DRB Application No.: 05DRB-00562 (P&F)

Project # 1004092

Project Name: MESA VERDE ADDITION

DEVELOPMENT REVIEW BOARD--SPEED MEMO

**PLAT OF
LOT 31-A-1 AND 31-A-2
MESA VERDE ADDITION
BLOCK 15
ALBUQUERQUE, NEW MEXICO
FEBRUARY 2005**

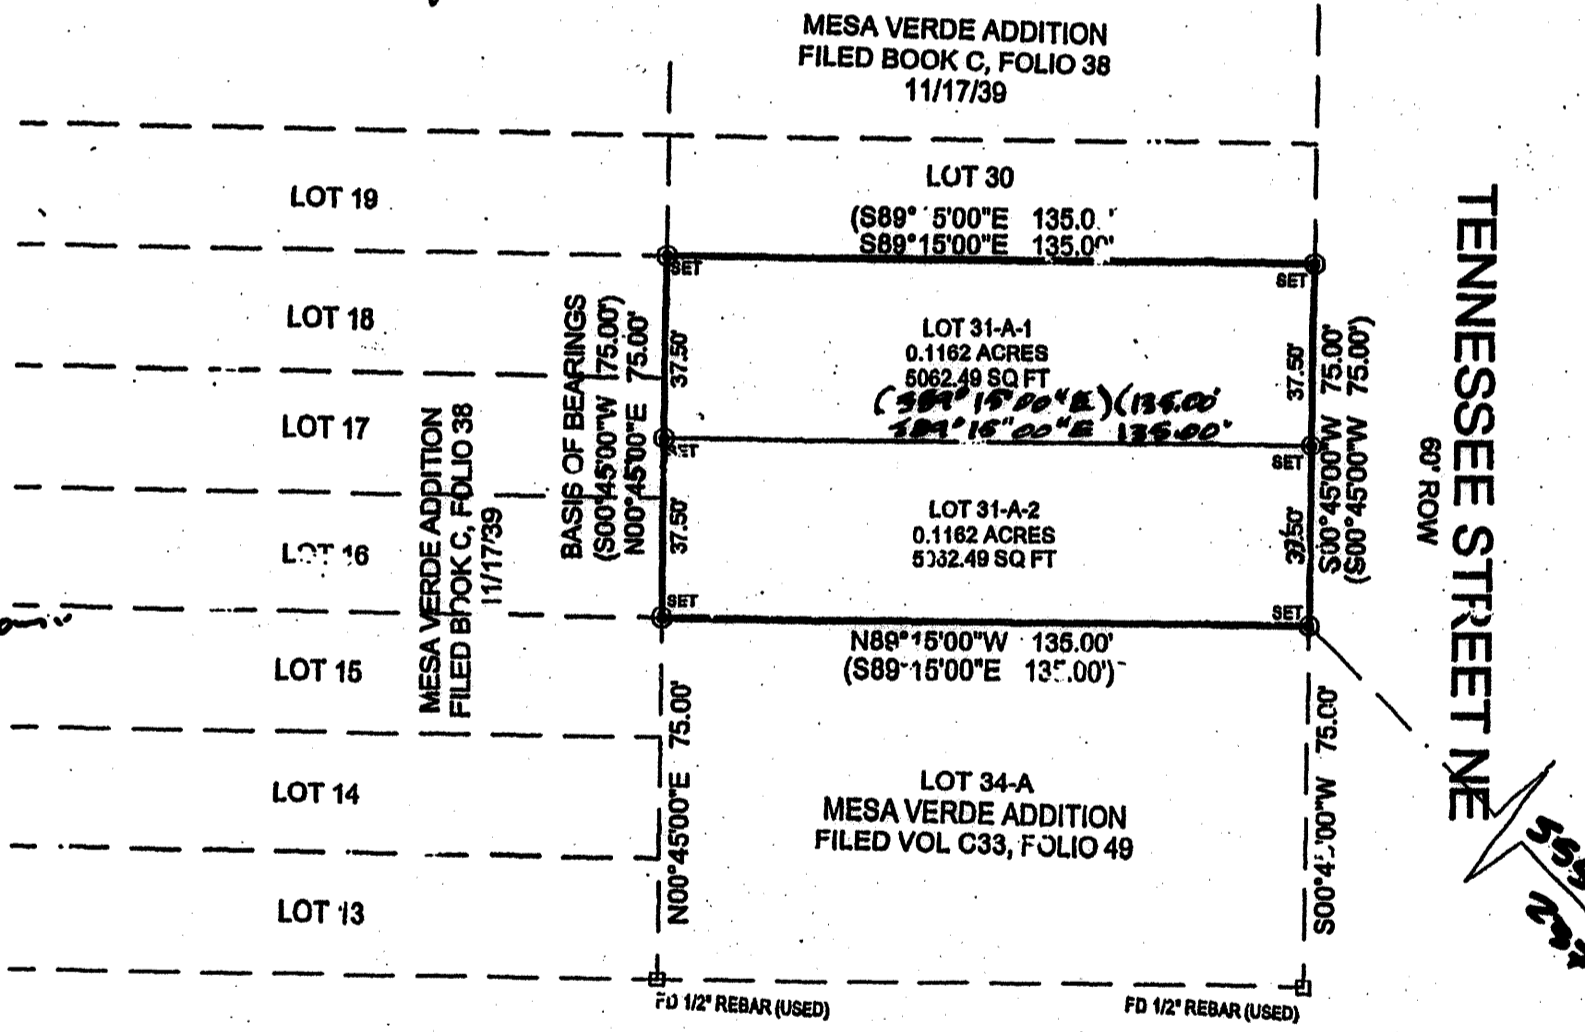
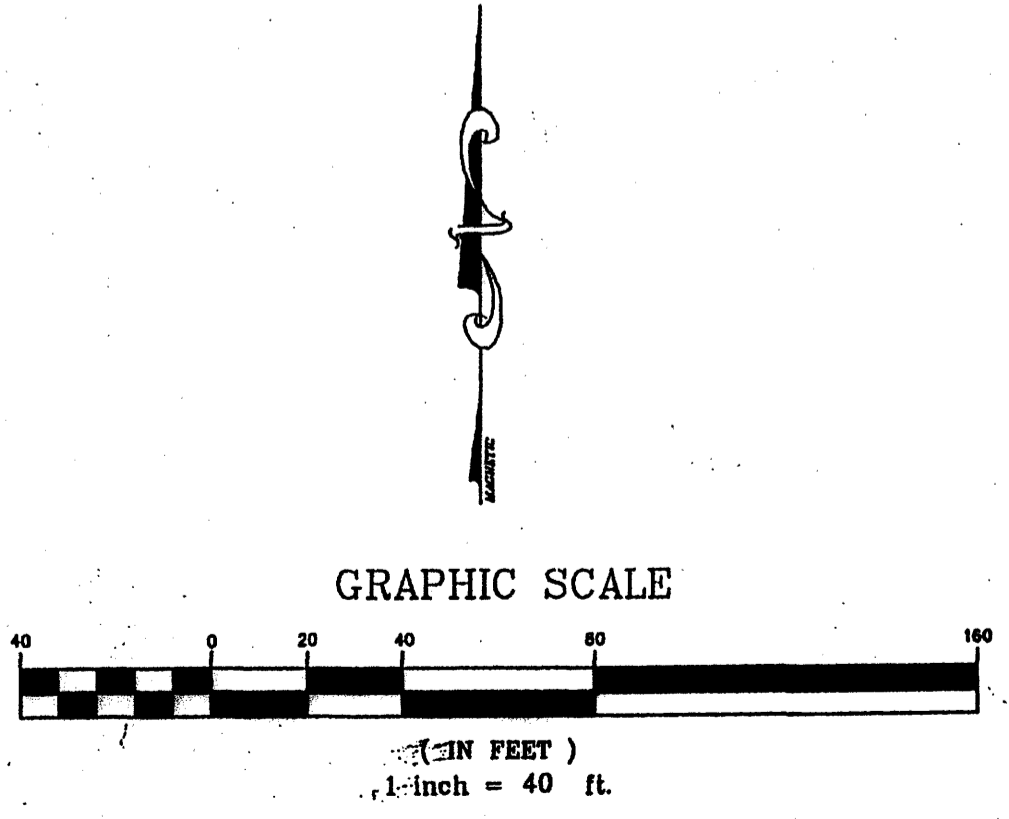
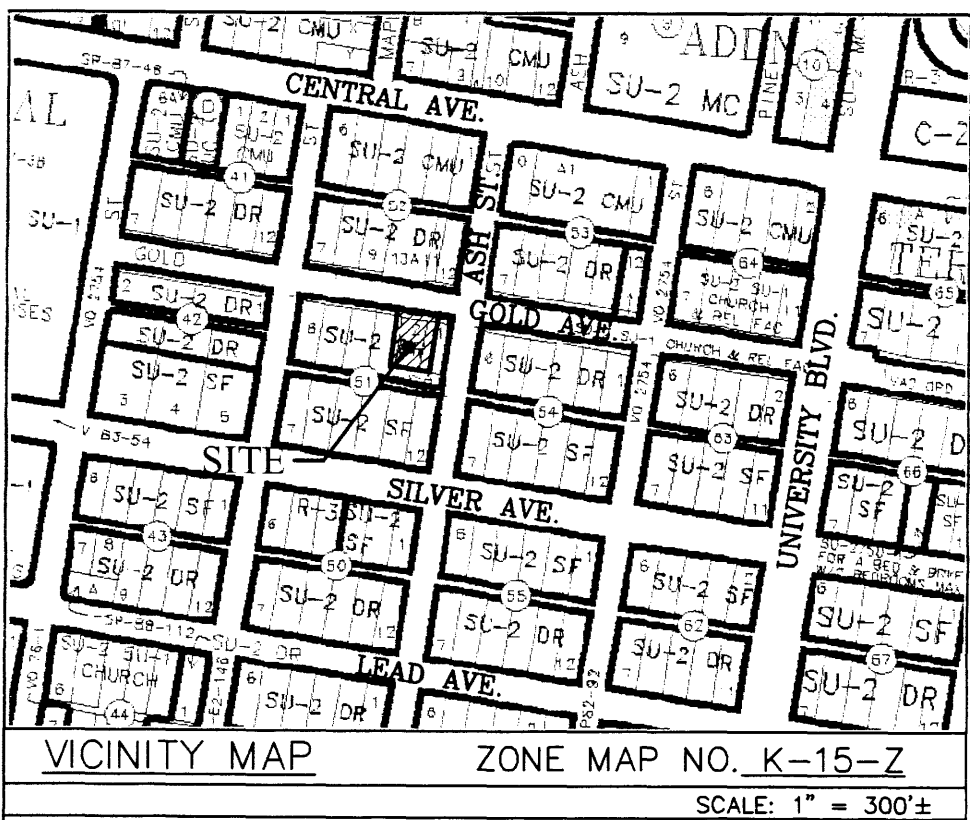
Need cross-lot drainage easement.
